**DELEGATED DECISION FOR APPLICATION FOR CERTIFICATE OF
LAWFUL DEVELOPMENT**

Reference no.: 2025/CL/92643/W

Site: 18, Westfield Avenue, Meltham, Holmfirth, HD9
5PY

Description: Certificate of lawfulness for proposed erection of
single storey side extension

Scale: 1:50 & 1:100	Drawing Number 2025/043/03	Rev. Rev. A	Date Drawn September 2025	Drawn By Andrew Smith
------------------------	-------------------------------	----------------	------------------------------	--------------------------

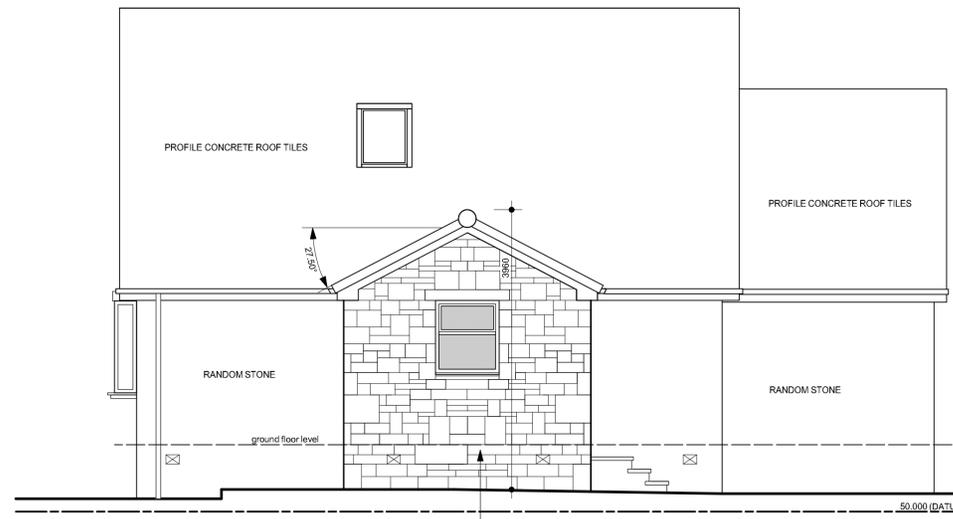
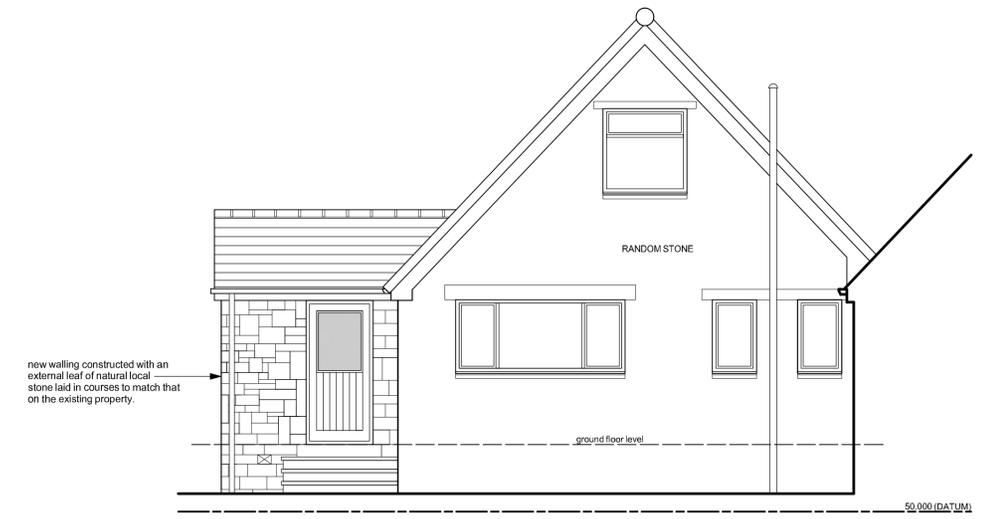
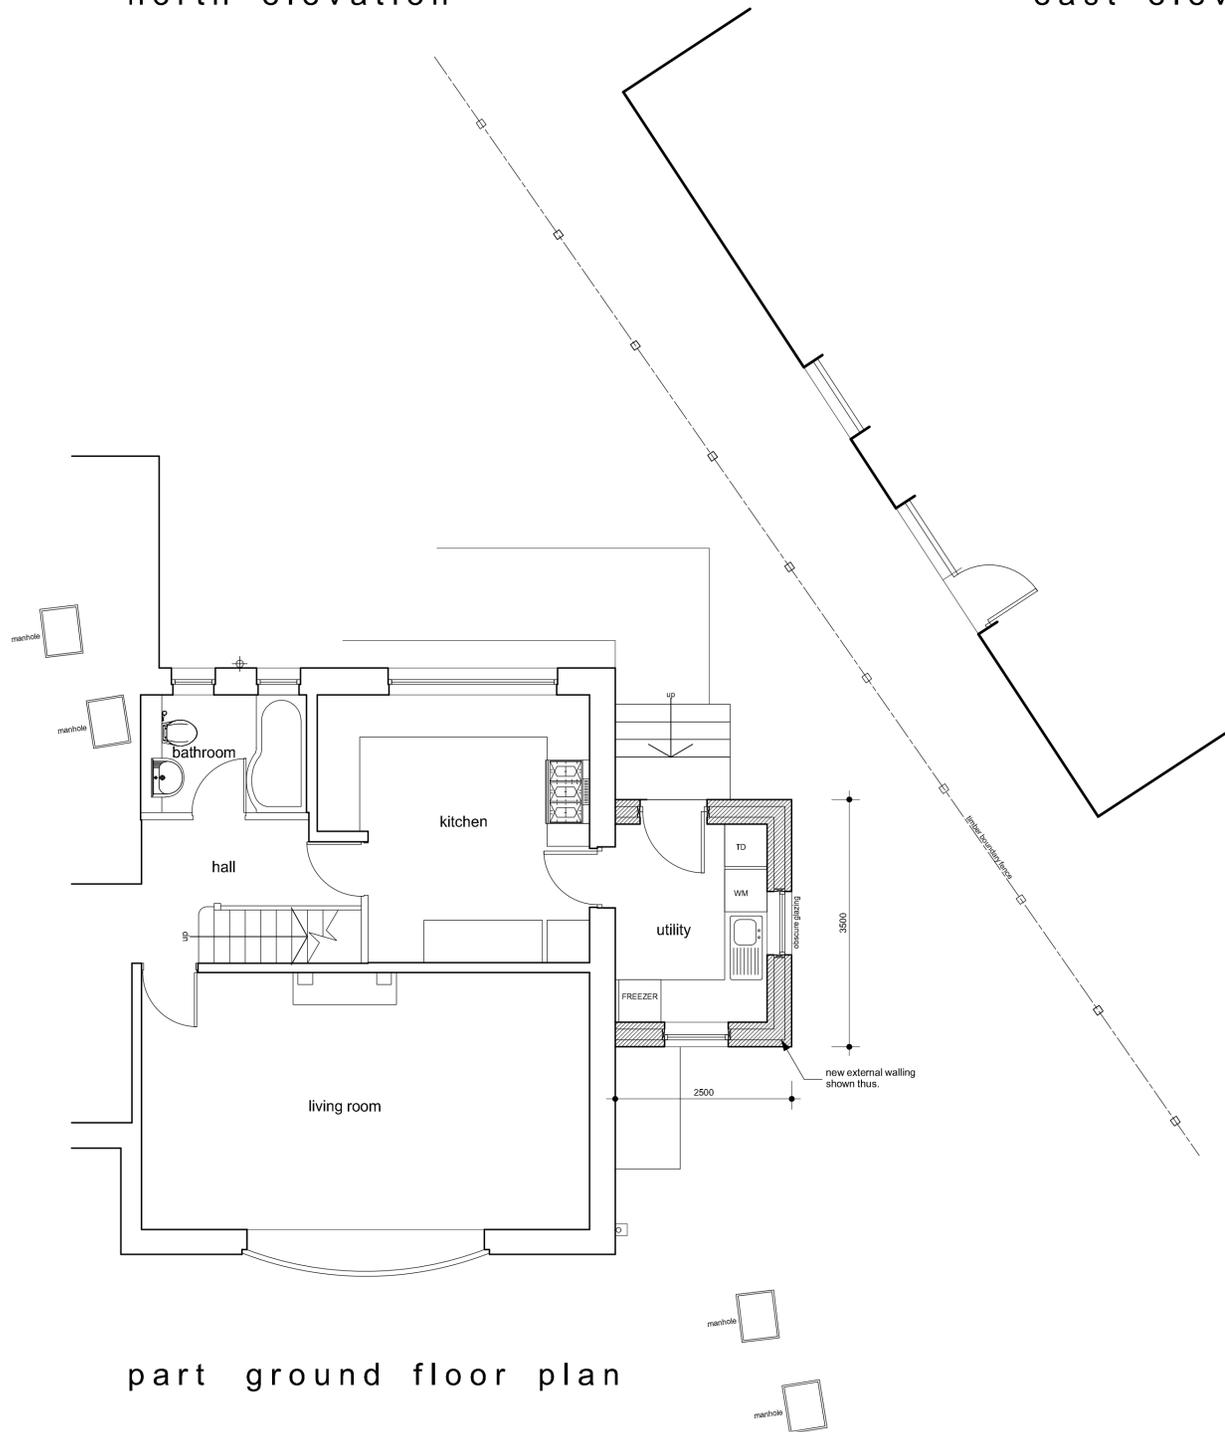
Comment: *The enlarged part of the dwellinghouse would extend beyond a wall forming a side elevation however it would not exceed 4 metres in height when measured from the adjacent ground level; would not have more than a single storey and would not have a width greater the half the width of the original dwellinghouse when measuring of the submitted elevational drawings.*

Comment: *Submitted drawing number 2025/043/03 annotates that the construction materials would be natural local coursed stone for the walls and interlocking roof tiles for the roof, all to match the existing dwellinghouse.*
